From: Richard Castro-Parker
Sent: 09 April 2019 11:14
To: Planning.Responses
Subject: FW: AL/88/18/PL
Attachments: PG.3047.18.4.revA.pdf

Firstly I apologise for the lack of contact regarding your clients application ref: AL/88/18/PL – Aldingbourne Cottage Rest Home. I have discussed the application today with the Area Manager and note the following:

PROPOSED FIRST FLOOR

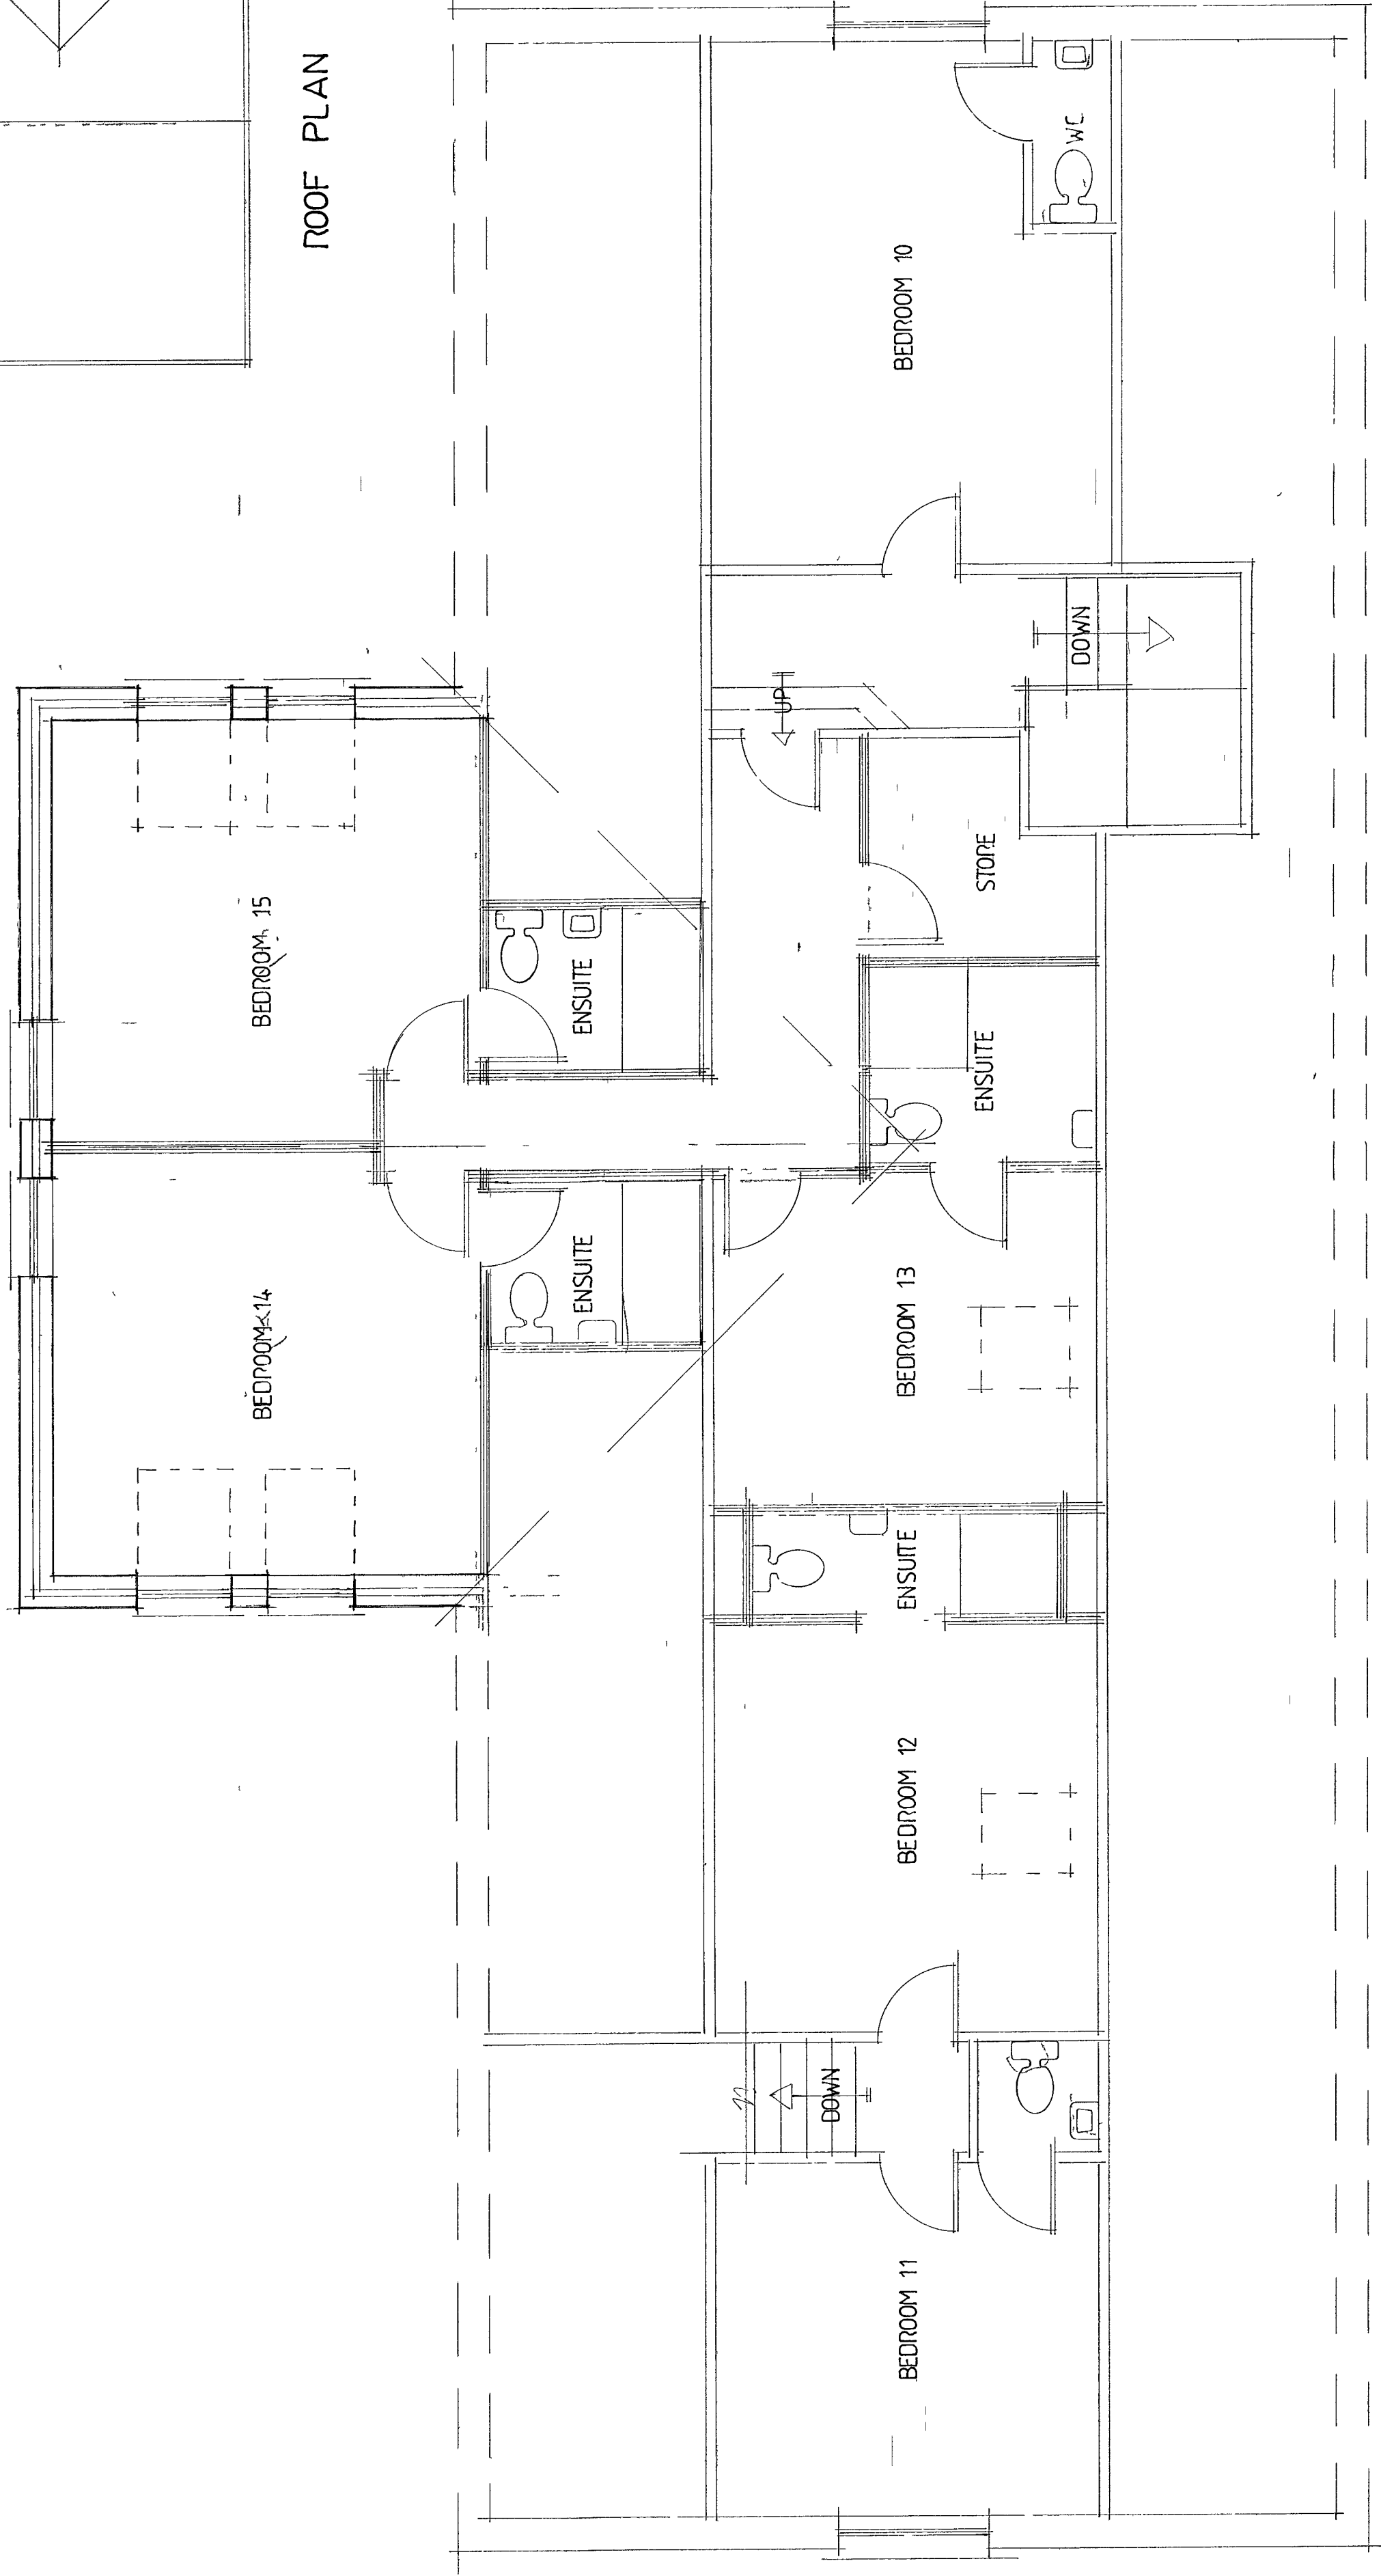
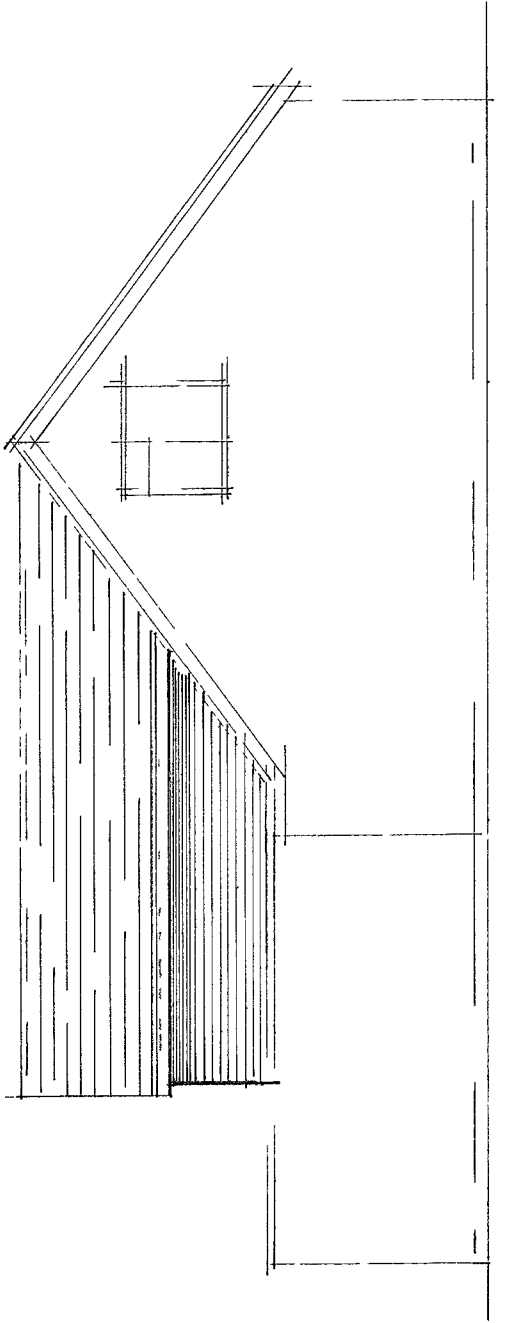
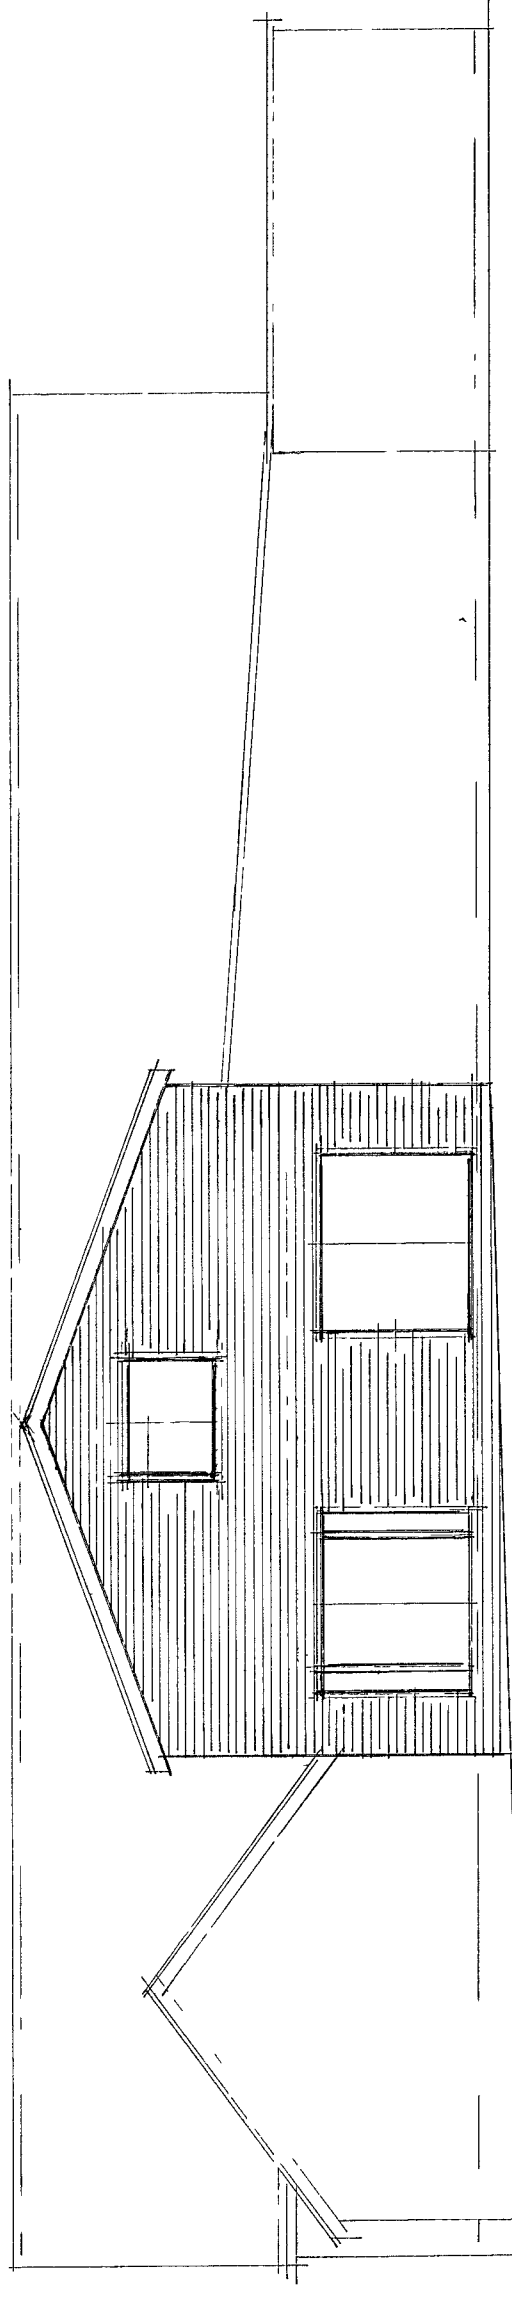
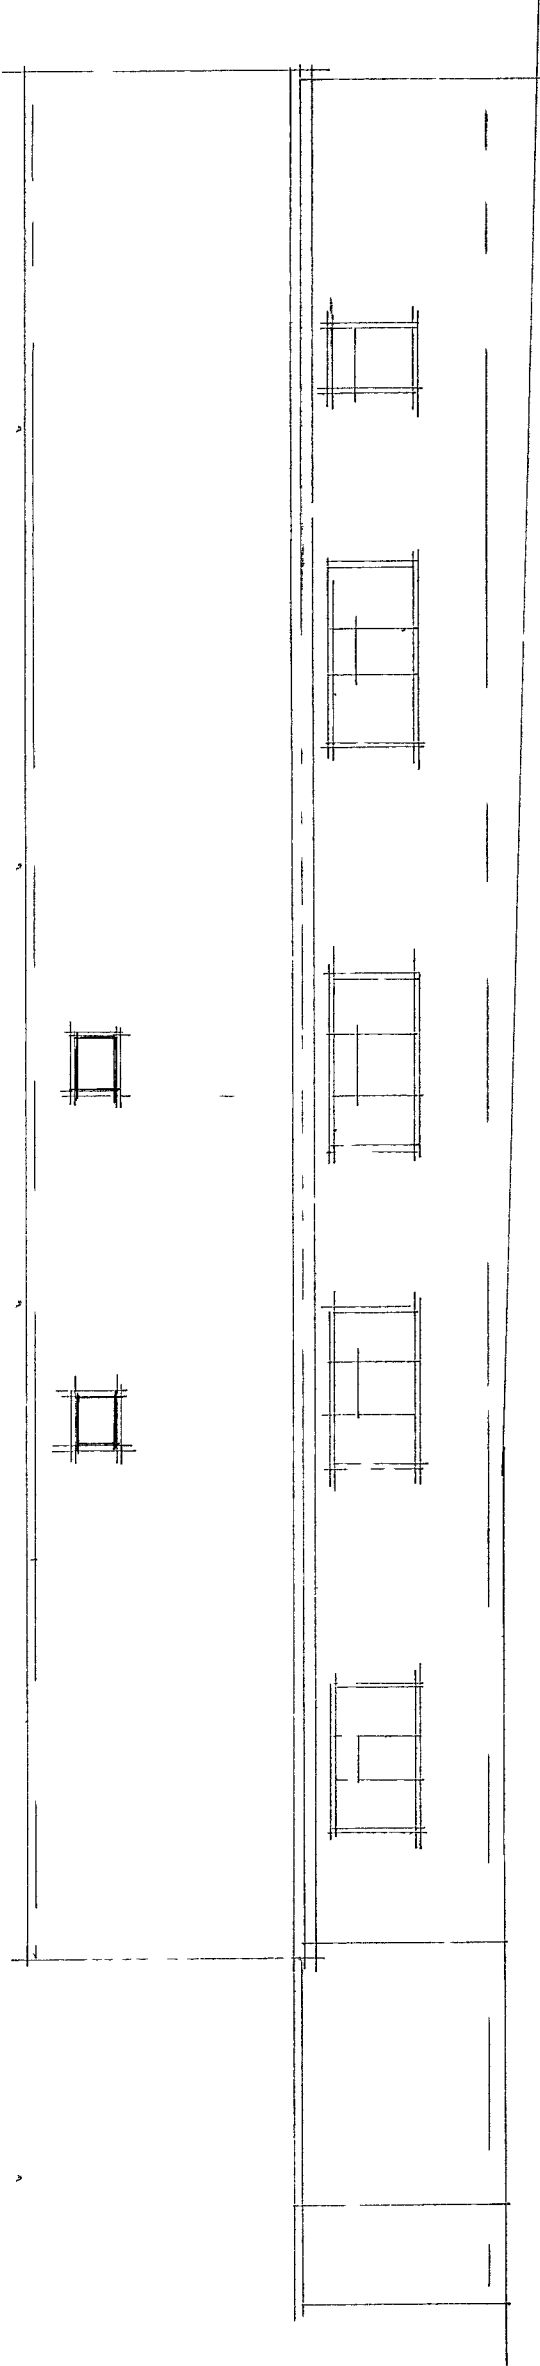
1. It is considered that there would be detrimental level of overlooking from the proposed first floor level windows in the rear elevation of the proposal facing adjoining property 5 Elmcroft Place. Officers note the neighbour comments raised from the Occupiers of 5 Elmcroft Place (this can be viewed on the council's website). Officers could impose a condition to obscure these windows but would not necessarily wish to do so if they are the only windows serving the bedrooms. (see point 2 below).

2. The plans seem to show a number of windows in the side elevation of the extension at first floor level but these are not shown on the side elevations. Please could this be confirmed. If the plans are meant to show windows within the side elevation/roof slope please could the plans be amended accordingly.

1. Our client would be happy to fit obscure glass to the side windows if necessary
2. The plans have been amended to correctly reflect the position of the windows – attached
3. With regards to the tree, the extension is an infill of the existing building and therefore any building works carried out will not affect the tree in question. All shrubs and trees will be unaffected. Any building works carried out will not be detrimental to the surrounding shrubbery.
